# SOUTHERN ENGINEERS

**PROJECT #:** 19-1621-C

**DATE:** June 24, 2020

**PLANS REF:** Rachford Residence by Design Tech

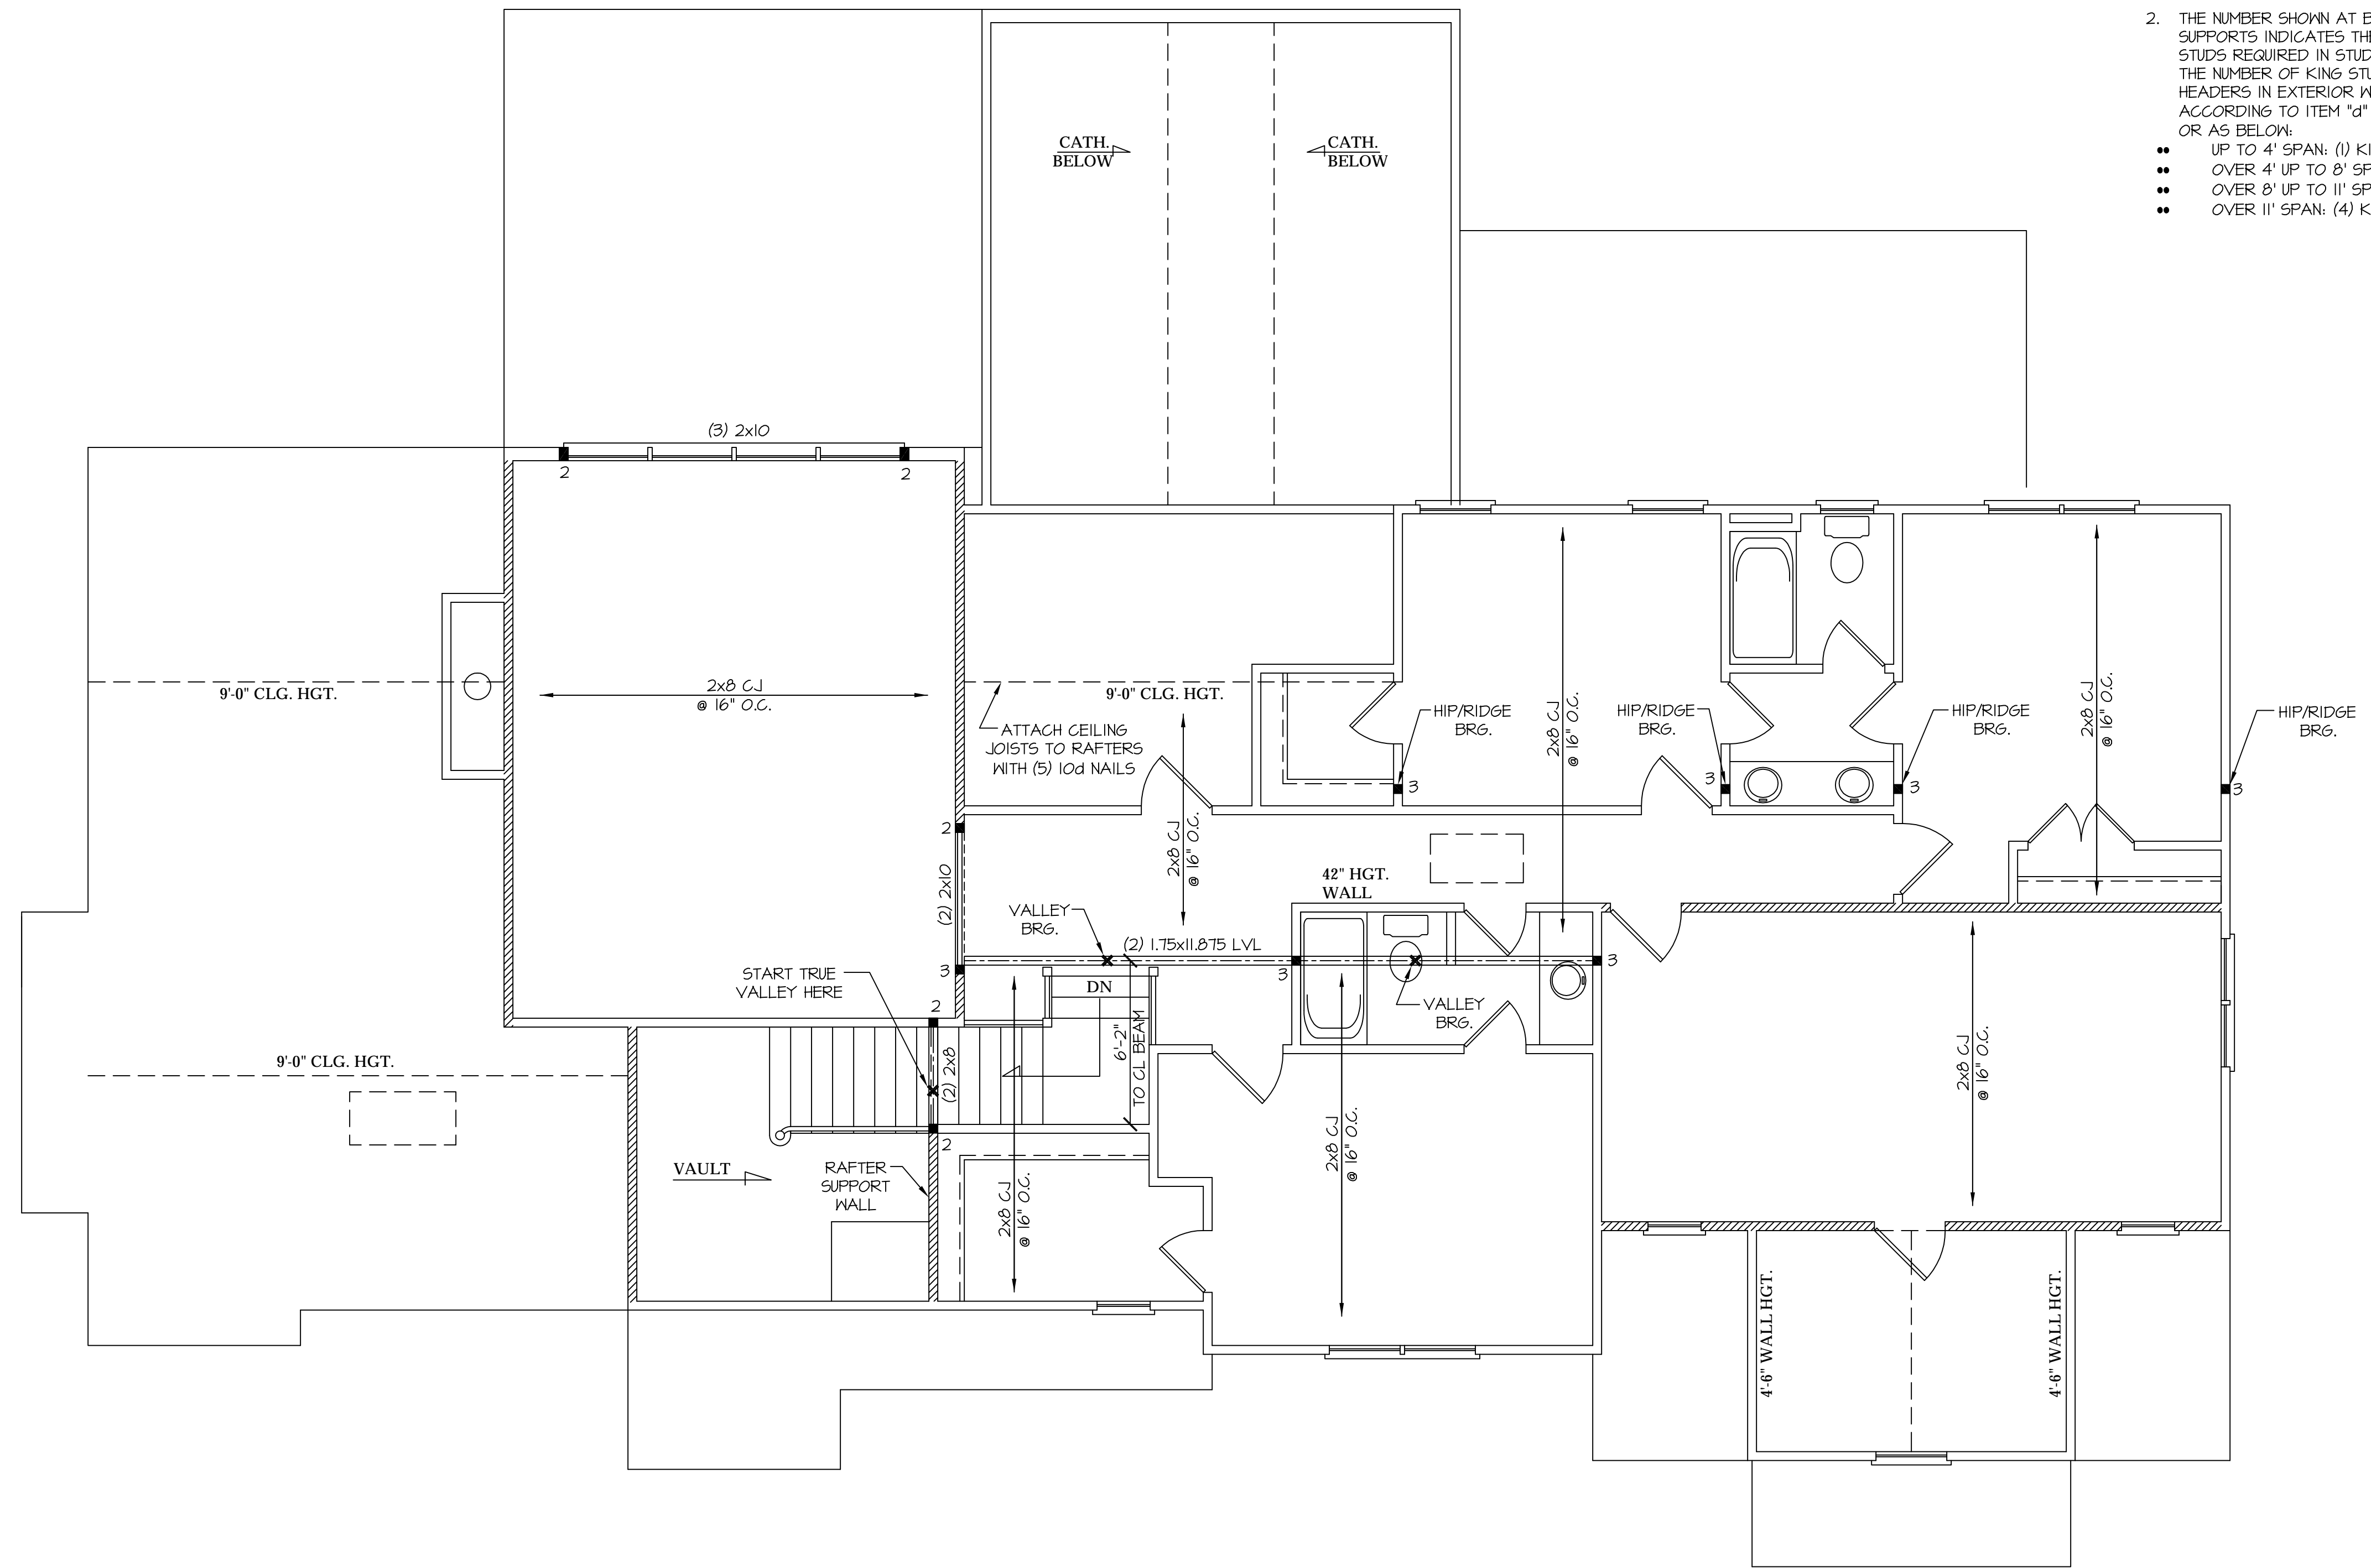
**Sun Room Back Wall:** Per information and pictures from builder a triple 2 x 10 header is continuous above and between the 2 twin windows. Each end of the header has (2) jack studs and (2) king studs.

Please be advised the above framing is structurally acceptable and therefore repairs are not required.
